# Bramford to Twinstead Reinforcement

Document 8.3.2.2: Applicant's Written Summary of Oral  
Representations to Issue Specific Hearing 1

Final Issue A  
September 2023

ELEVATION - B  
 SCALE 1:150

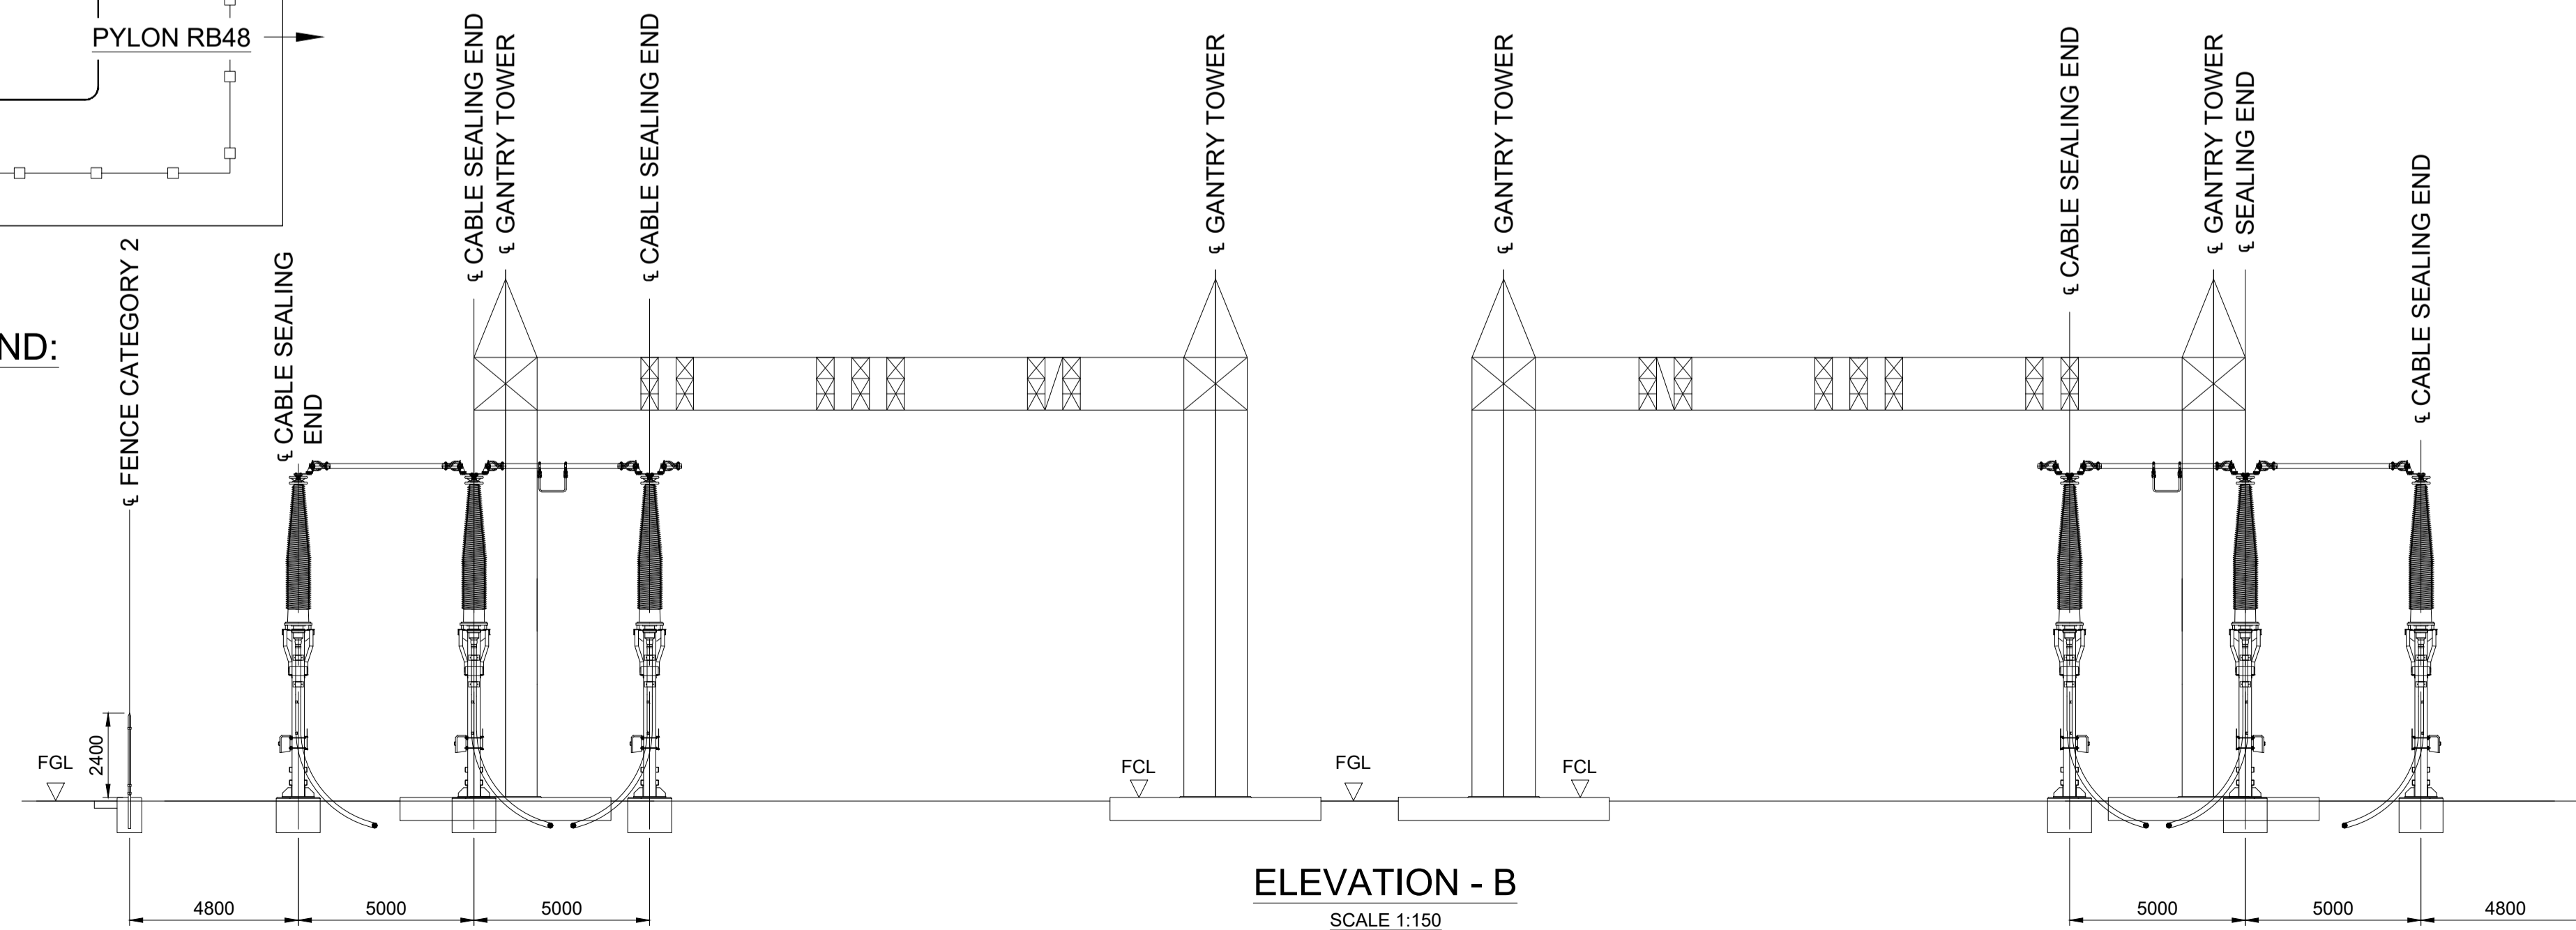
#### **Stour Valley East CSE Compound**

The equipment used within the CSE compound, as per Design and Layout Plans Stour Valley East Cable Sealing End Compound [APP-025], is in accordance with technical requirements and with other similar compounds utilised throughout the National Grid network. The size of the compound is circa 45m x 70m and is necessary to accommodate the required equipment and to provide a safe and secure compound throughout the asset life.

The LoD for the CSE compound are intended to allow the main works contractor, once appointed, some flexibility with the final positioning / layout of this compound. This assists with the detailed design of the compound and the interface positions between the underground cable and overhead line whilst at the same time constraining the position of the CSE compound within the area assessed.

The LoD have been derived by applying a 25m buffer zone on each side of the CSE compound dimensions, as per Design and Layout Plans Stour Valley East Cable Sealing End Compound [APP-025] which allows for the repositioning of the compound to suit final overhead line / underground cable alignments, or to relocate equipment items if needed to avoid unexpected ground conditions.

At the CSE Compounds the non-linear LoD and the linear LoD overlap to allow for all equipment to be accommodated within the LoD.
